Botany Rail Duplication (SSI-9714)

TAB A – Detailed Comments on the SSI

Figure 29 Residual Triggered Receivers after Lubrication Used

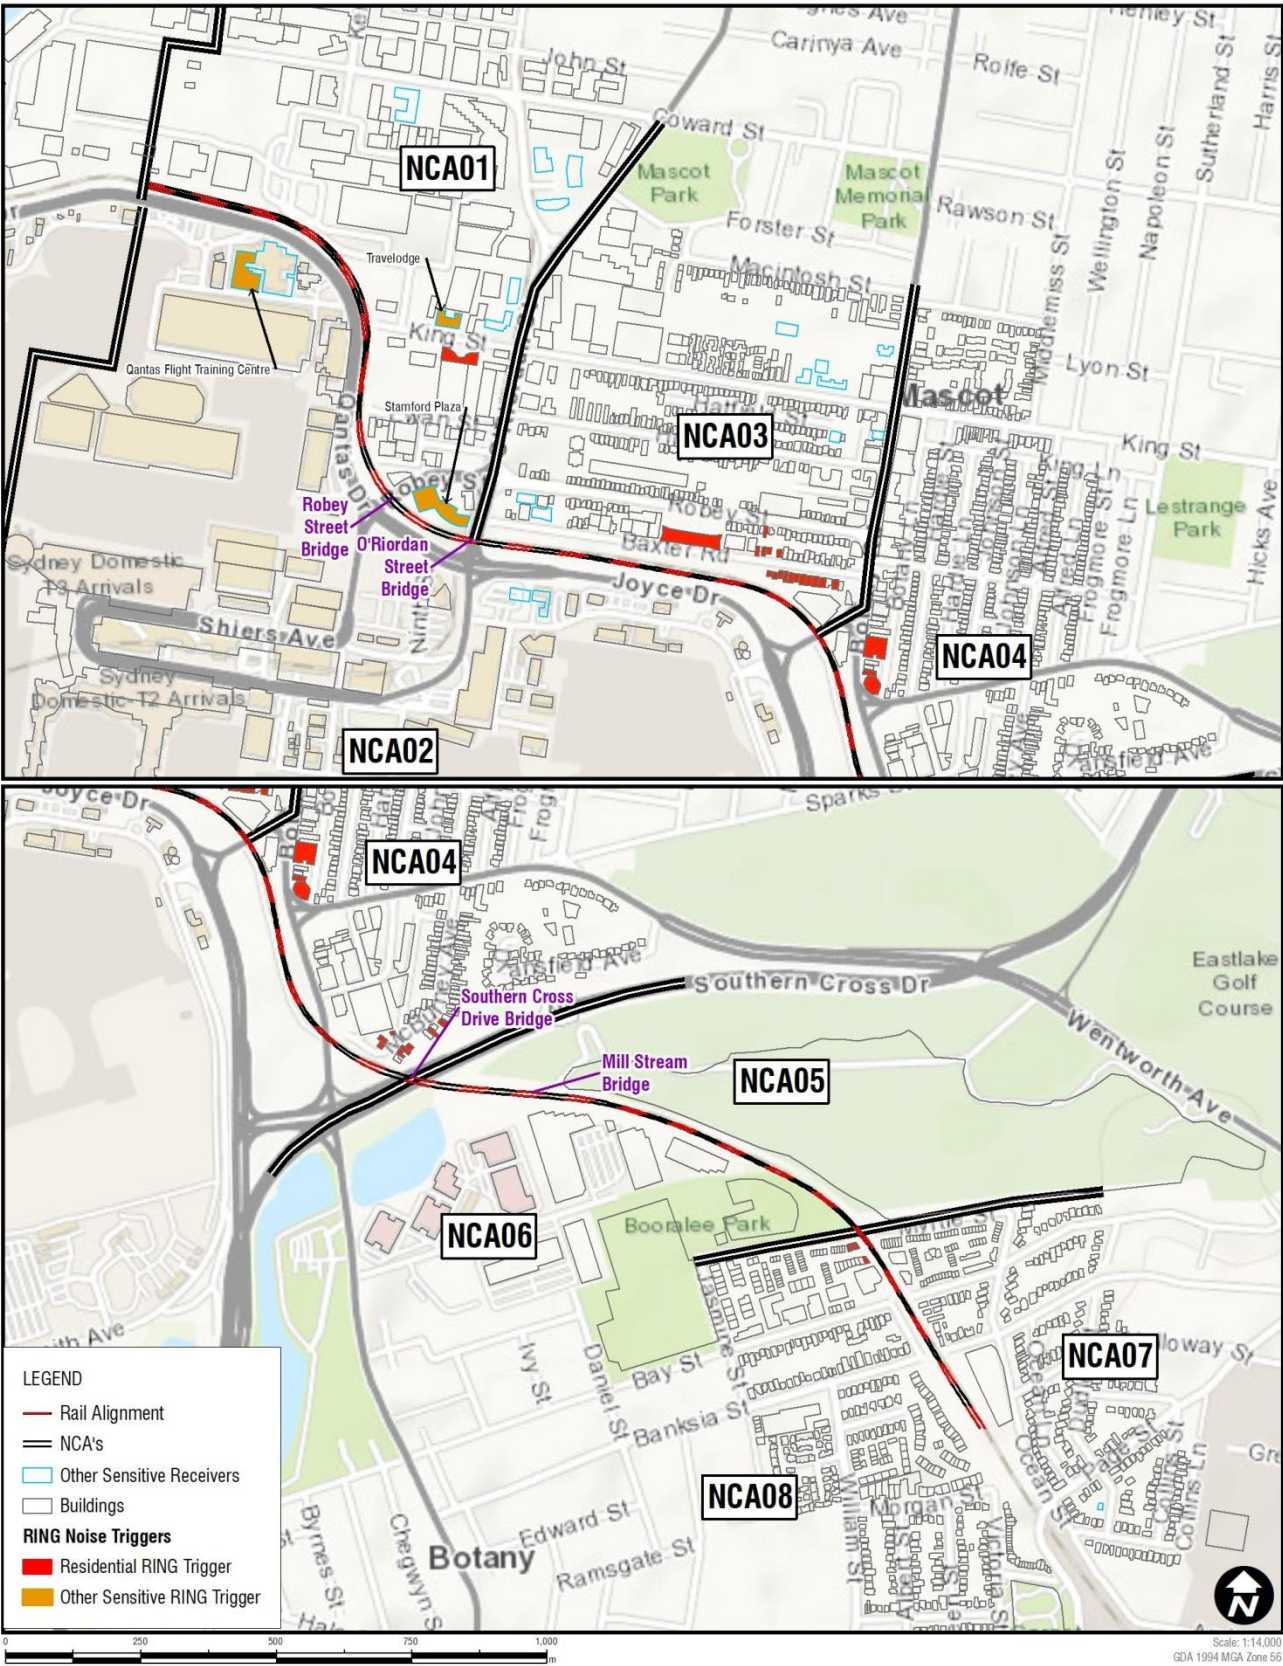
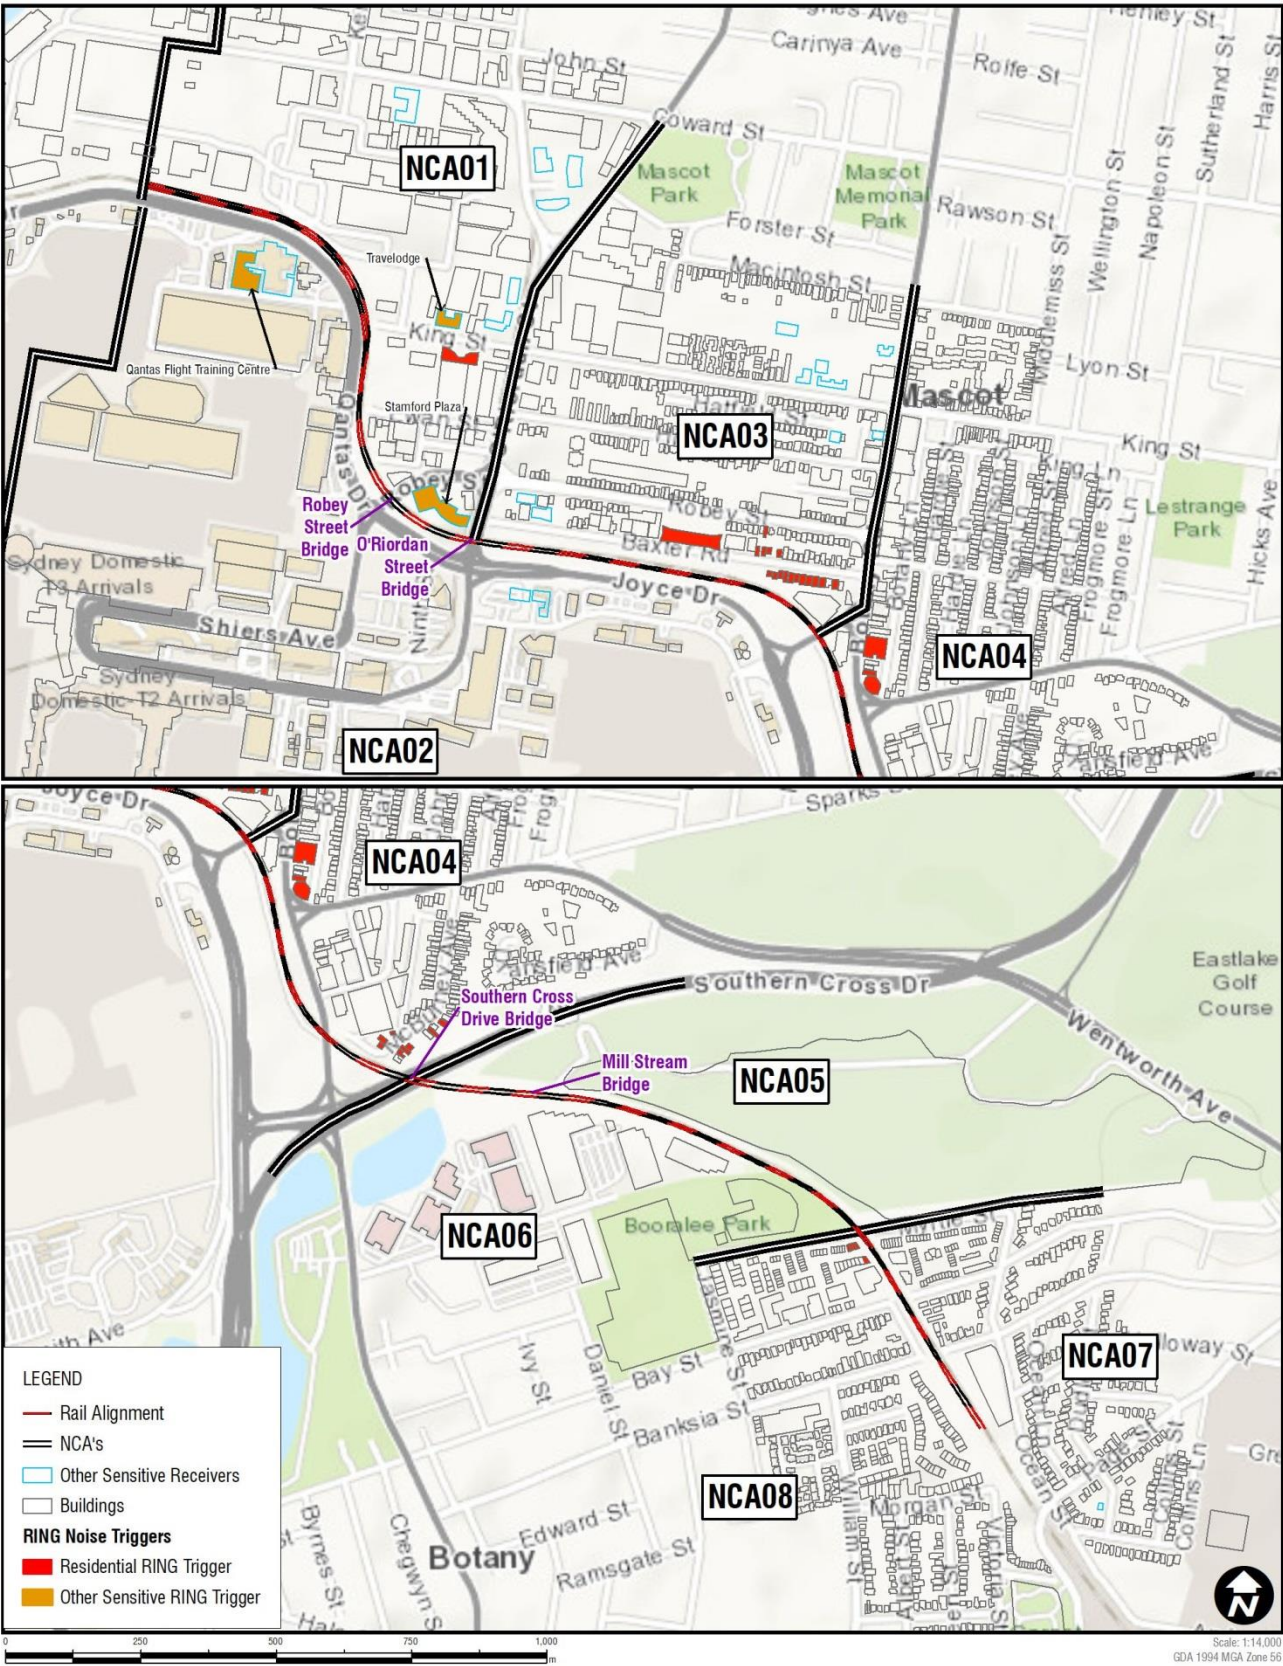
Section 8.1.1 states that modern track lubrication systems are recognised as a cost-effective means of minimising curve noise. Section 8.3.1.1 states that studies undertaken in NSW have shown that curve noise from freight operation can be reduced by 1 dB and 8 dB for LAeq and LAmax respectively.

- TfNSW has identified a greater noise reduction than that stated in section 8.3.1.1 (see 2011 paper by Jiang et al 'Field trials of gauge face lubrication and top-of-rail friction modification for curve noise mitigation'); and
- Track lubrication is most effective when it is used in combination with other at-source treatments such as improved wagon steering and should not be seen as a standalone treatment.

The applicant shall carry out track lubrication in combination with other at-source treatments such as improved wagon steering to reduce the noise levels.
